## **HCC Highway Authority Update to Deadline 7**

Hampshire County Council, in its role as Highway Authority, provides this update to offer further explanation in support of its position as set within the Statement of Common Ground (SoCG) at deadline 7 ahead of the February hearings. This update takes account of additional submitted evidence from the applicant at deadline 6 and further meetings held between deadline 6 and 7.

Figure 2: Swept Path Analysis - A3/Portsmouth Road / B2149

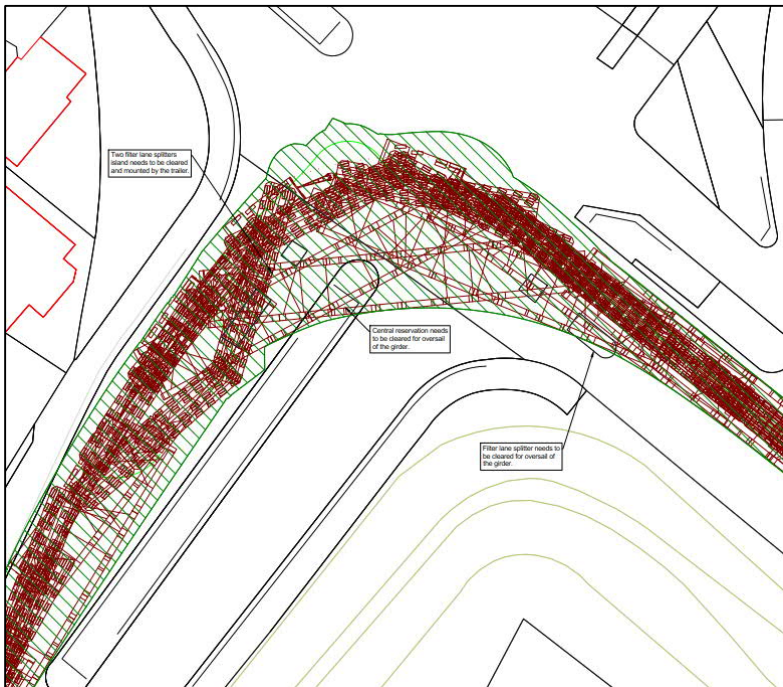
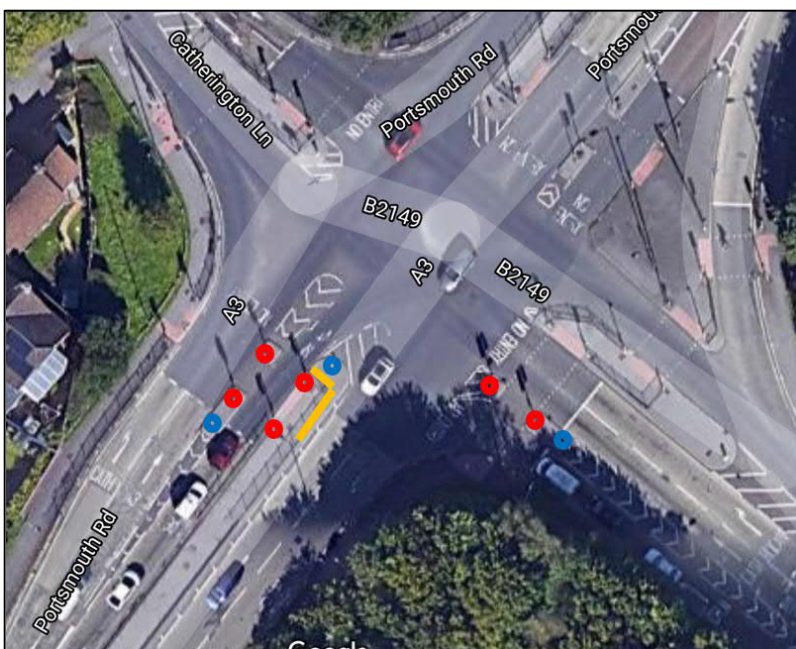
Whilst the Highway Authority are generally accepting of the temporary amendments required to facilitate the movements, questions remain over the process and triggers for making the necessary junction amendments. The works required to install the retention sockets are required ahead of the AIL movements taking place. However, it is currently unclear where the necessary timeframes are secured within the DCO and also how this will work in practice i.e. when will the Highway Authority's ITS team be informed of the required changes? How will the cost of these junction changes be mitigated? Who and under what mechanism will the non ITS work be undertaken? It is noted that one of the signs at the Lovedean Lane junction is lit and therefore requires engagement with SSE under HA's private finance initiative agreements.
